Drawing updated to Rev. 1, 29.02.2024 following comments from planning officer.

**Proposed works:  
11 Marlborough Avenue,  
Bromsgrove B60 2PG**

**Proposed Elevations**

Proposed Elevations

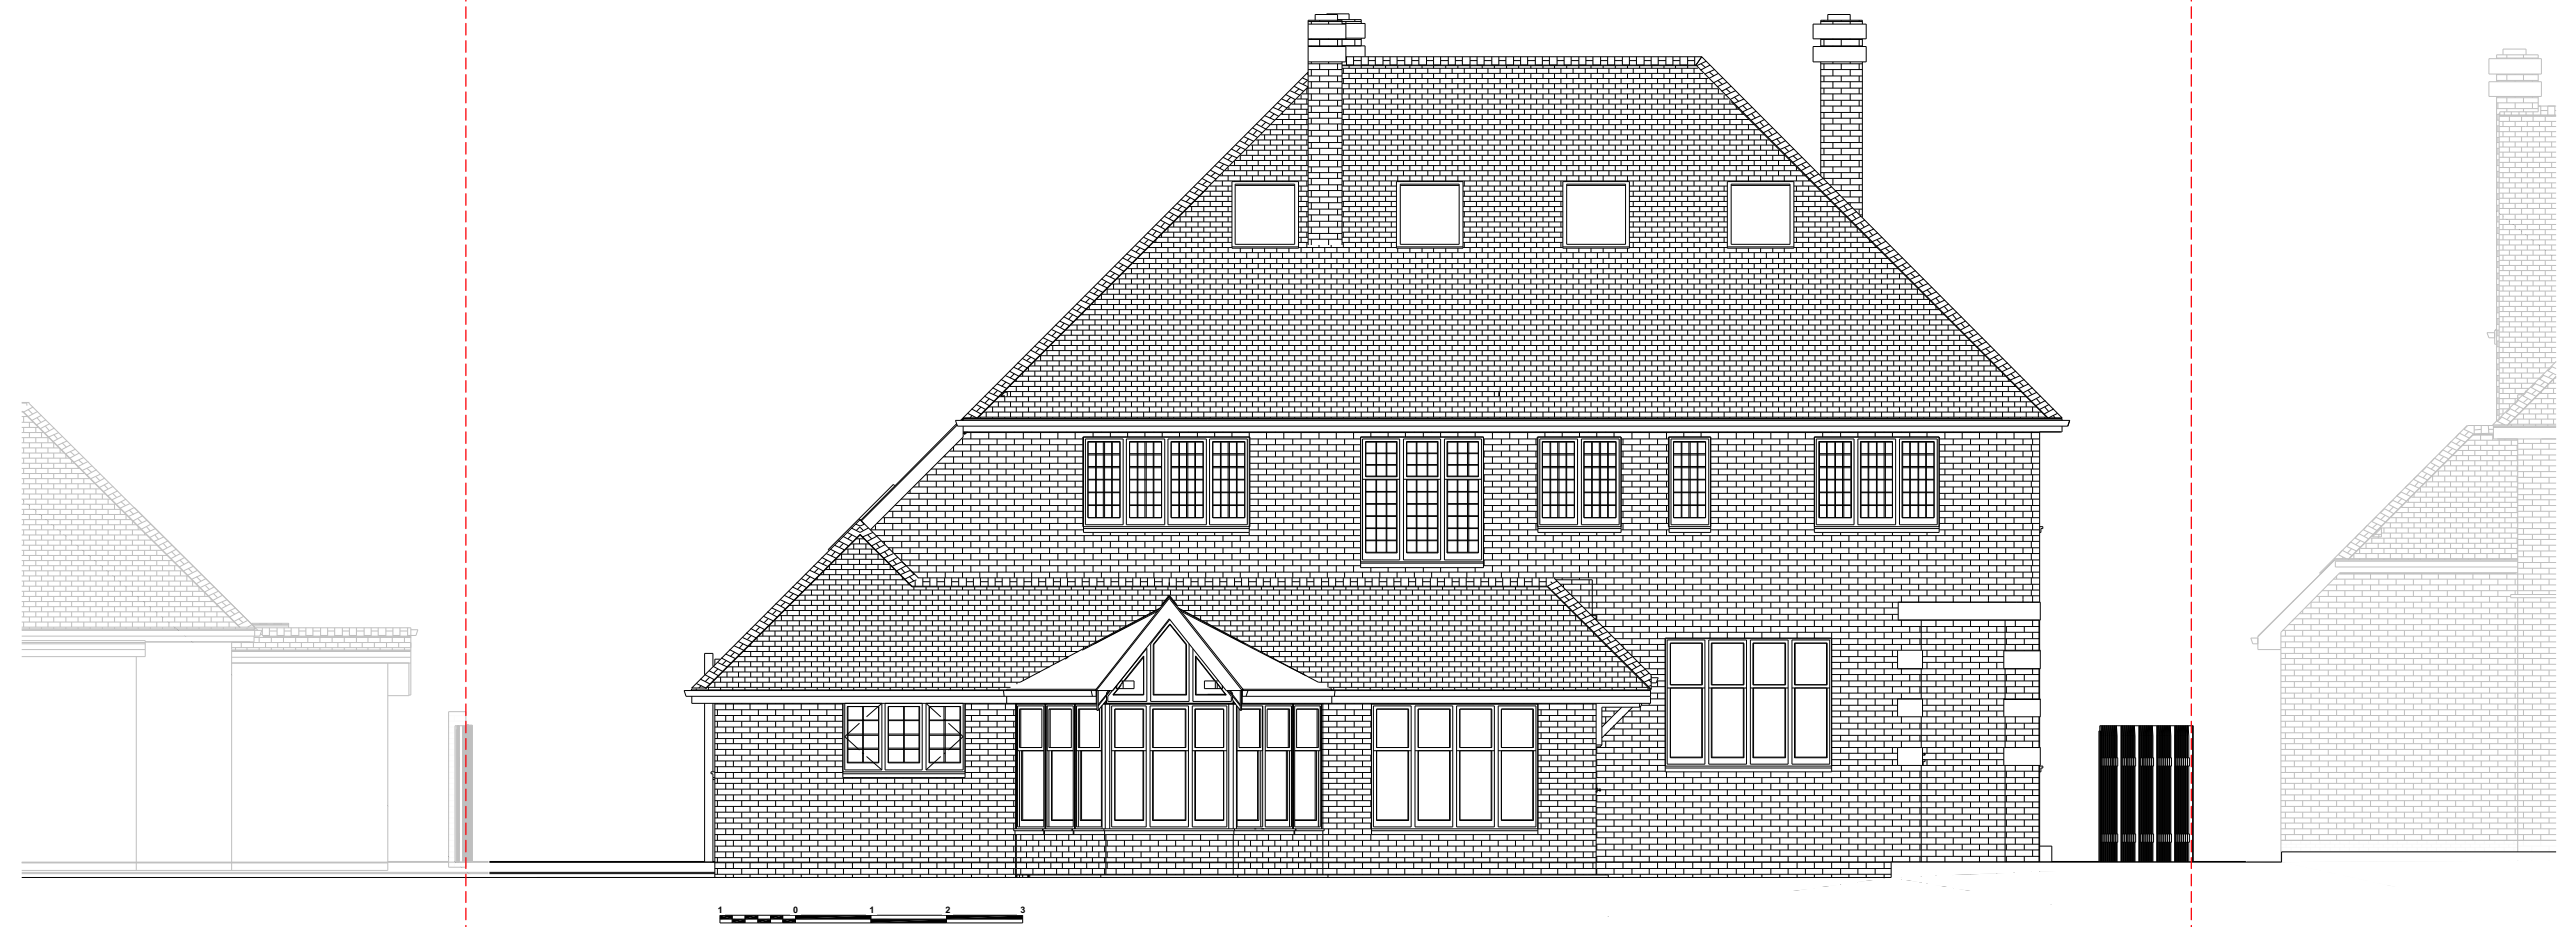
New timber dormers to be finished in dark grey GRP with clay/ concrete pitched tile roof to match existing.
